**Consultation Response from KC,
Highways Development Management****2021/94599 Moorhouse Farm, Moorhouse Lane, Birkenshaw, BD11 2AY****Erection of 6 dwellings and associated works****Date Responded: 15-03-2022****Responding Officer: Mark Berry****Responding Ref: 8-12SW-1**

Client: <b>Mr &amp; Mrs Light</b>	
Project: <b>Redevelopment Proposal Moorhouse Farm Moorhouse Lane, Birkenshaw, BD11 2AY</b>	
Drawing: <b>Proposed Site Layout</b>	
Date: <b>Nov 2021</b>	Scale: <b>1:750 @ A3</b>
Drawing No: <b>2077/110</b>	Rev: <b>A</b>

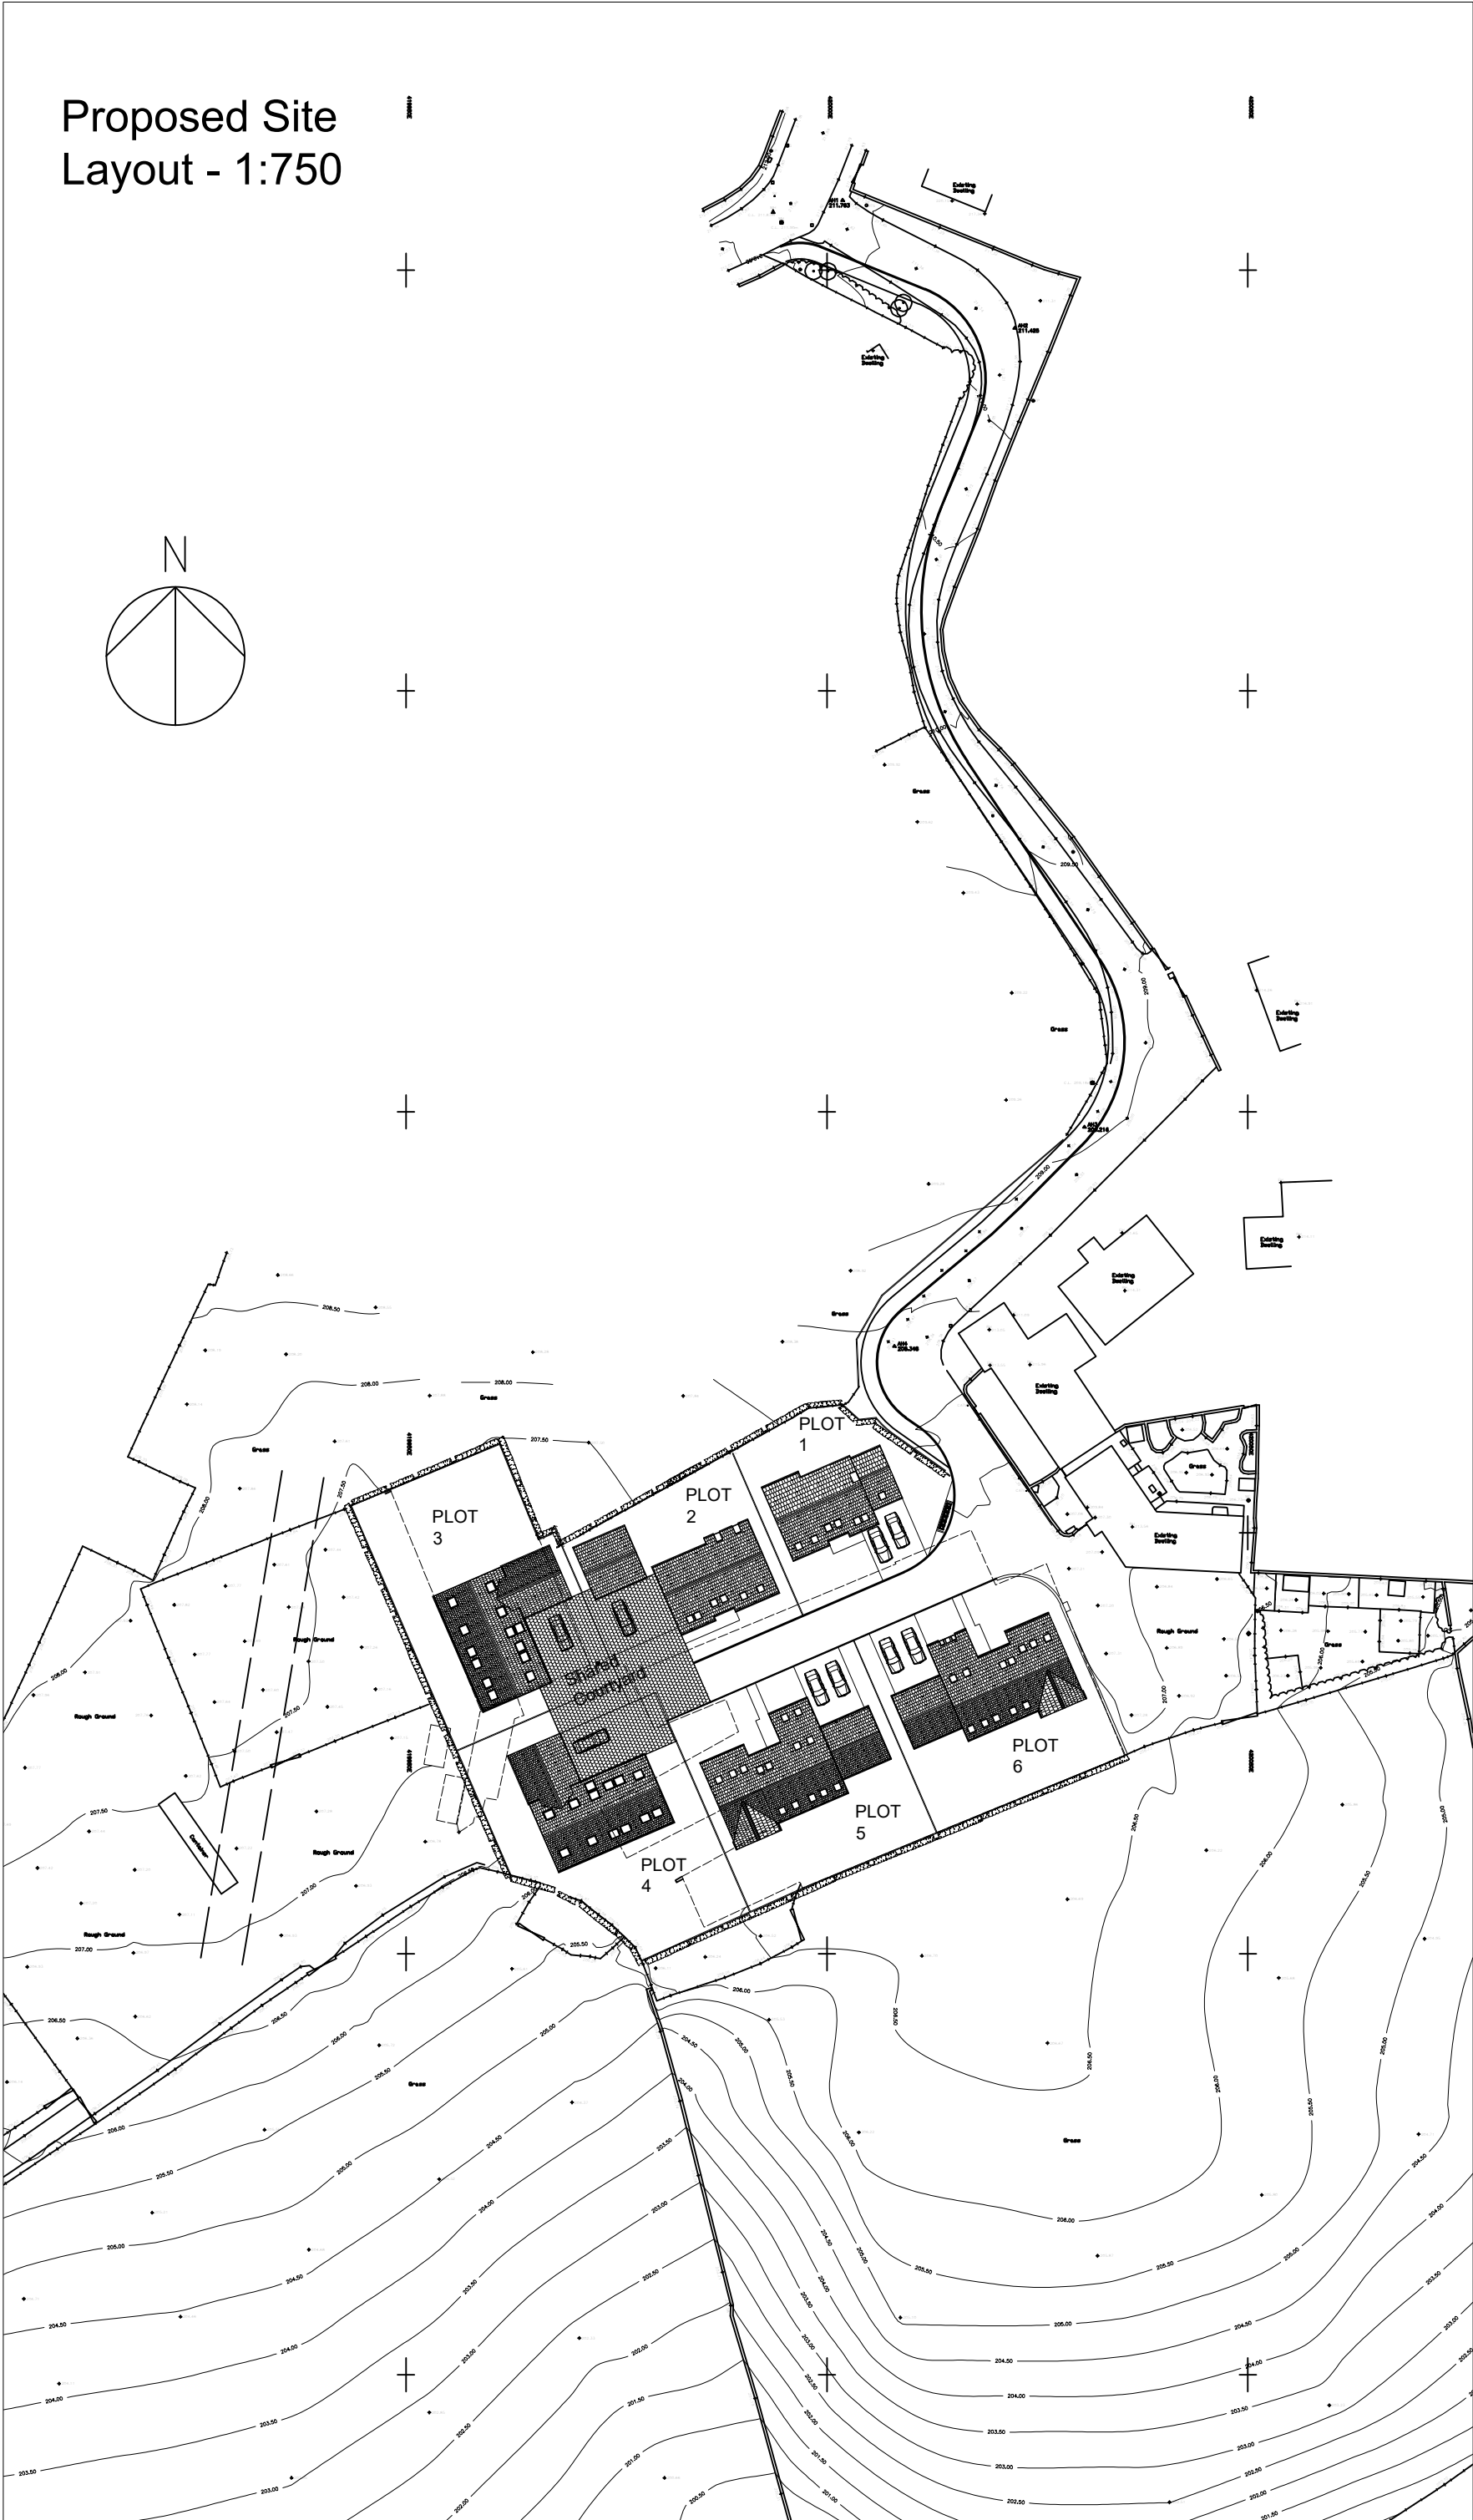
The existing driveway arrangement currently contains points of restricted carriageway widths which presently do not allow for two-way traffic flow. As part of the development, improvements and alterations are proposed to allow for the widening of the carriageway to at least 4.8 metres allowing for simultaneous two-way traffic flow along with a 2-metre footway to one side.

It is also proposed to improve visibility at the junction with Moorhouse Lane with splays of 2.4 x 33 metre provided on both sides.

The driveway improvements will accommodate a Kirklees Council refuse vehicle and allow the vehicle to safely enter and exit the shared driveway arrangement in a forward gear, negating the requirement for any lengthy reversing movements. Furthermore, the proposals will provide internal turning for a large fire appliance within the courtyard area.

Moorhouse Lane is to be improved with access retained to existing dwellings, the proposals include sufficient off-street parking for the proposed dwellings and internal refuse vehicle and fire service turning and overall, the proposed residential use could generate less vehicular traffic than the previous use.

HDM therefore consider these proposals acceptable.

Notwithstanding the details shown on the approved plan 2077/111 rev A, a scheme detailing arrangements and specification for layout and parking have been submitted to and approved in writing by the Local Planning Authority. Before any building is occupied the development shall be completed in accordance with the details shown on the approved plans and retained thereafter.

Notwithstanding the details shown on the approved plan, the development shall not commence until a scheme detailing the provision of *widening of the Moorhouse Lane shared driveway to at least 4.8 metres (allowing for simultaneous two-way traffic flow) along with a 2-metre footway to the western side as shown on Paragon Highways plan number 1919-101 rev A*, construction specification, surfacing, drainage and kerbing and associated highway works has been submitted and approved in writing by the Local Planning Authority. The development shall not be brought into use until the approved scheme has been implemented and thereafter retained throughout the lifetime of the development.
